Our ref: NO/2012/103211/04-L01
Your ref: 3/2011/1064
Date: 20 June 2012

PROPOSED RESIDENTIAL DEVELOPMENT SCHEMES TOTALLING 113 DWELLINGS (81 MARKET AND 32 AFFORDABLE UNITS). COMPRISING 81 DWELLINGS ON LAND OFF WOONE LANE ADJACENT TO PRIMROSE PHASE 1 SITE (OUTLINE APPLICATION INCLUDING DETAILS OF ACCESS, LAYOUT AND SCALE) AND 32 DWELLINGS ON LAND TO REAR OF 59-97 WOONE LANE (DETAILED APPLICATION PLUS RELATED HIGHWAY IMPROVEMENTS AT WHALLEY RD/PRIMROSE JUNCTION SITES OFF WOONE LANE A) REAR OF 59-97 WOONE LANE AND B) LAND TO SOUTH-WEST OF PRIMROSE VILLAGE PHASE 1, CLITHEROE

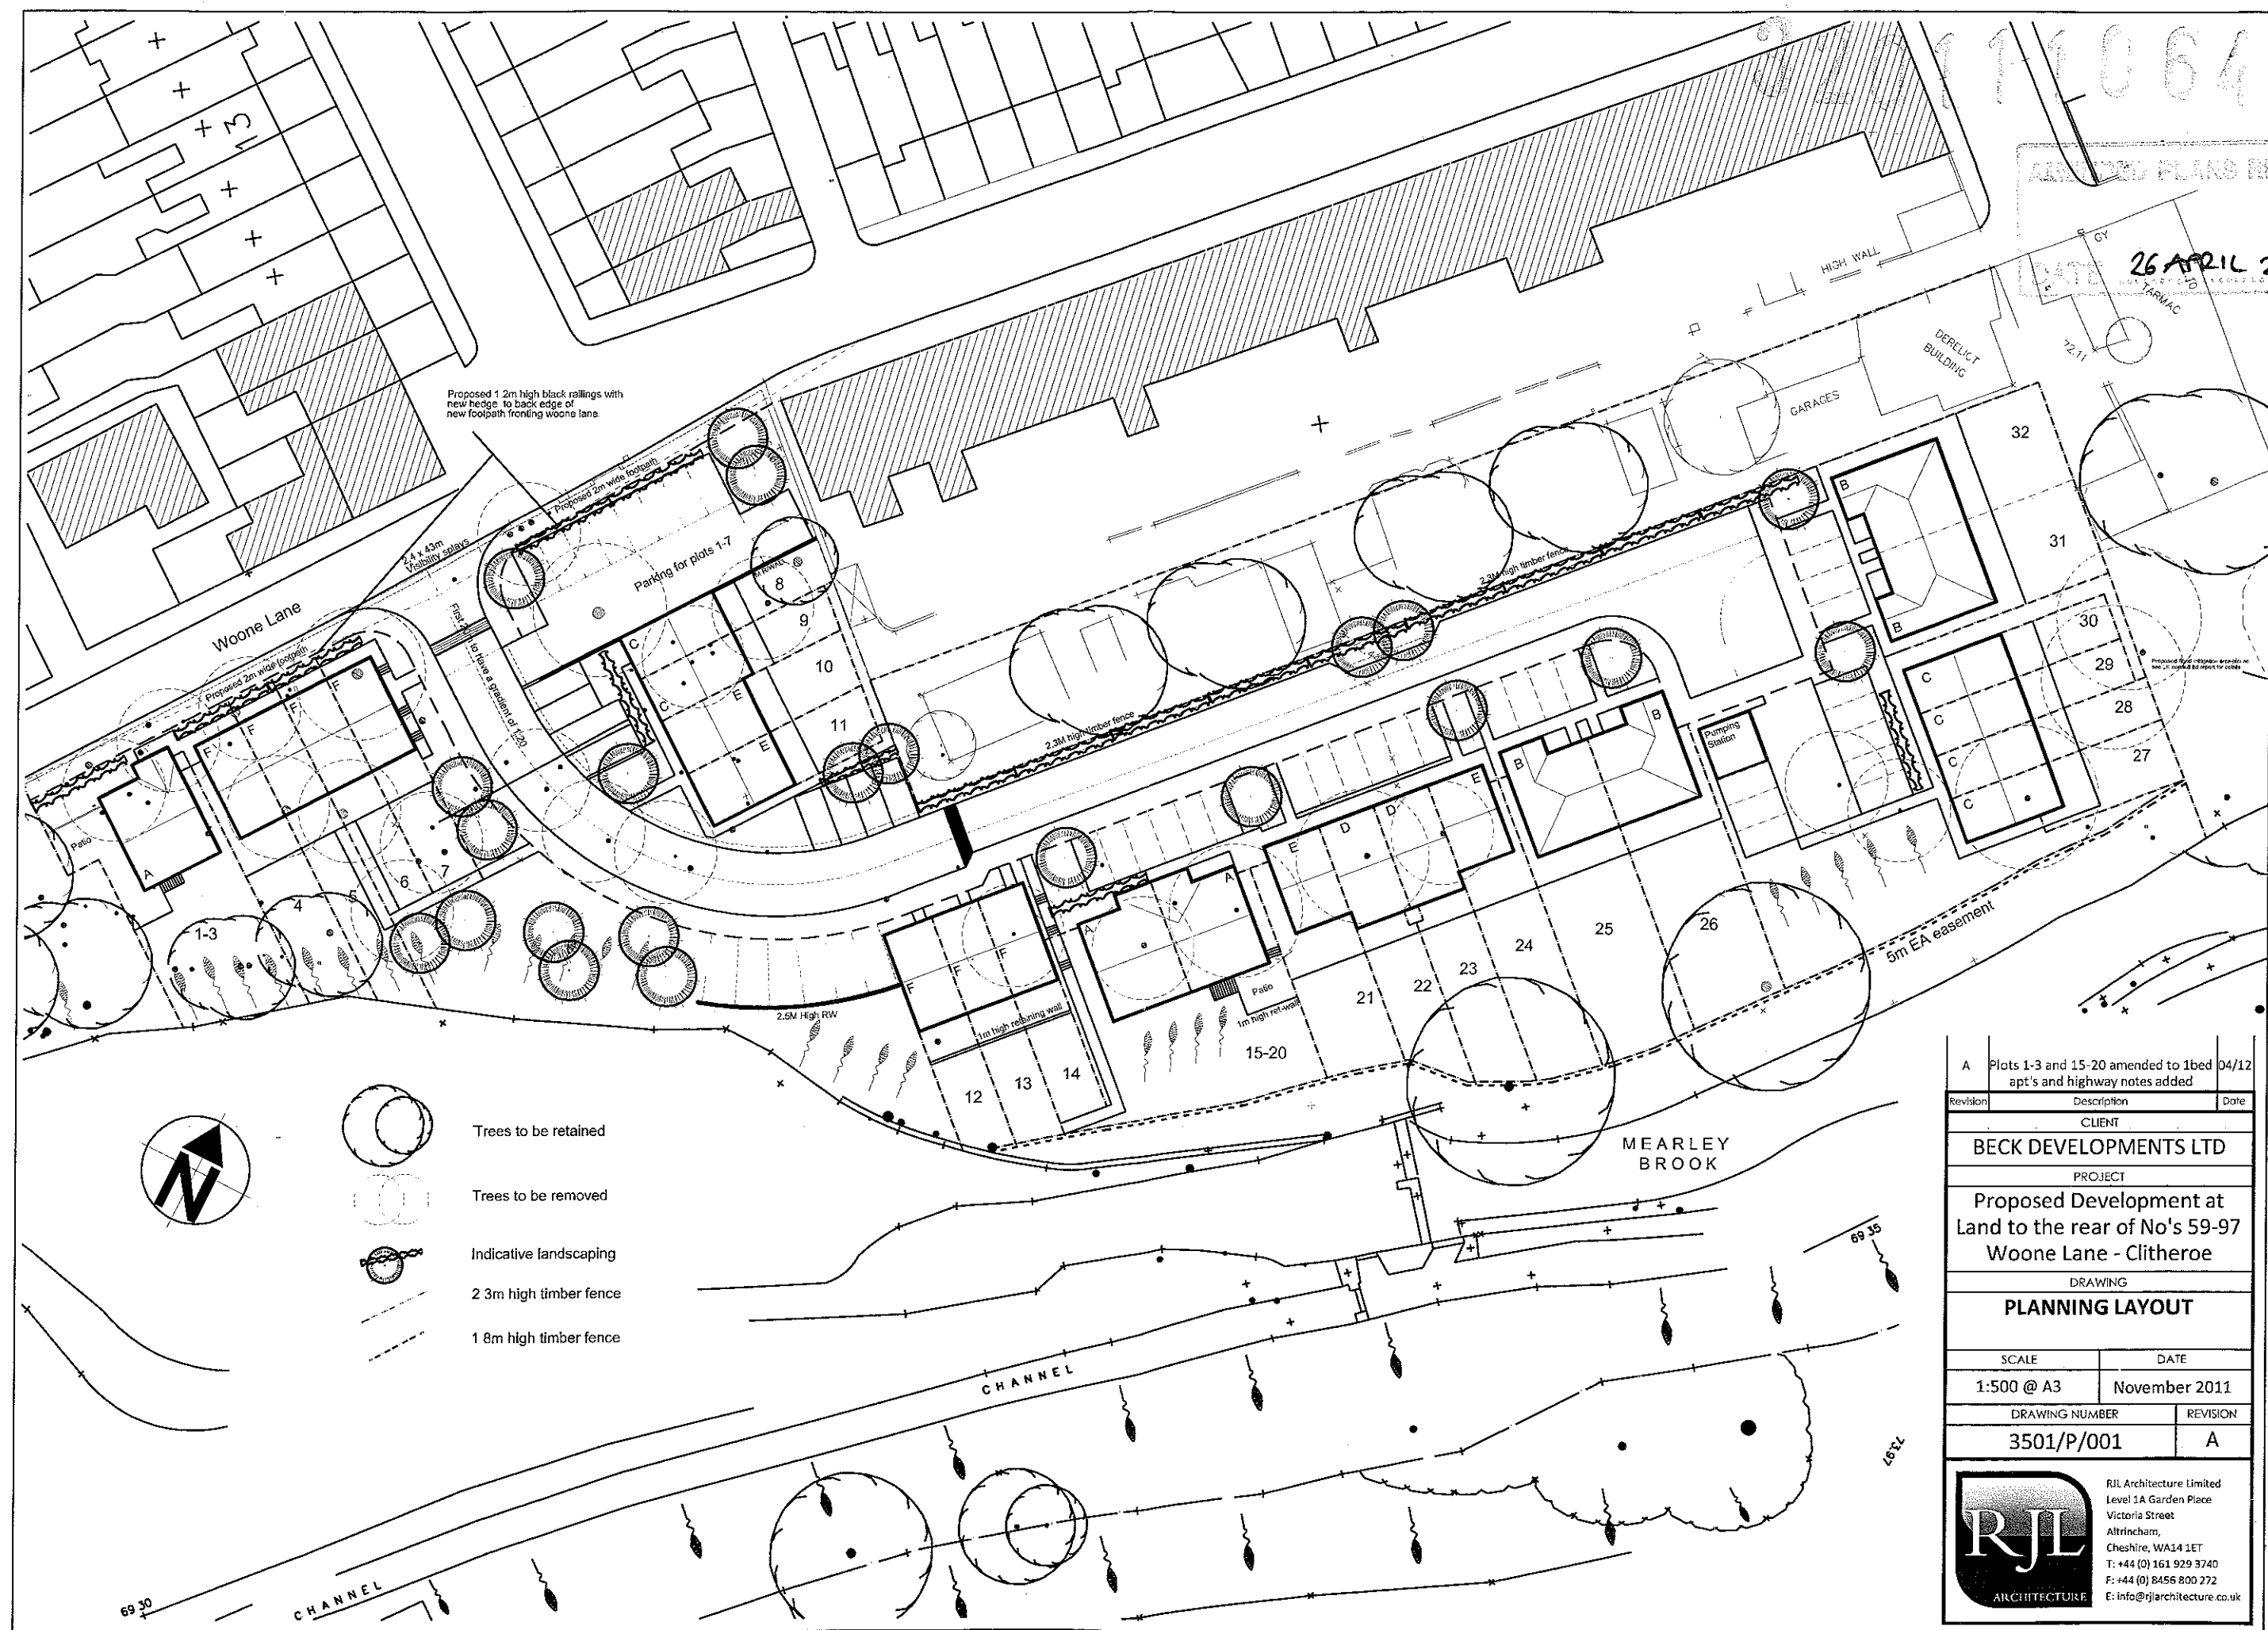
We have subsequently received additional information via e-mail from Phil Hunter (LK Group) on 12 June 2012 regarding our access to the adjacent watercourse and the compensatory flood storage proposals. A further e-mail, dated 19 June, including a copy of a revised site plan (dwg. no. 3501/P/001 Rev B 'Planning Layout' by RJJ Architecture) was subsequently received and copied to the council.

Based on the additional information as submitted and the revised layout as proposed, we are satisfied that the proposed compensatory flood storage proposals are acceptable. A scheme for access to Mearley Brook for maintenance and/or repair has also been incorporated into the revised layout. As such, **we withdraw our objection** to the proposed development.

The proposed development will only meet the National Planning Policy Framework (NPPF) policy to prevent the risk of flooding elsewhere if the following planning condition is included:

CONDITION The development hereby permitted shall not be commenced until such time as a scheme to for the provision of compensatory flood storage works-

has been submitted to, and approved in writing by, the local planning authority. The scheme shall be fully implemented and subsequently maintained, in accordance with the timing / phasing arrangements embodied within the scheme, or within any other period as may subsequently be agreed, in writing, by the local planning authority.
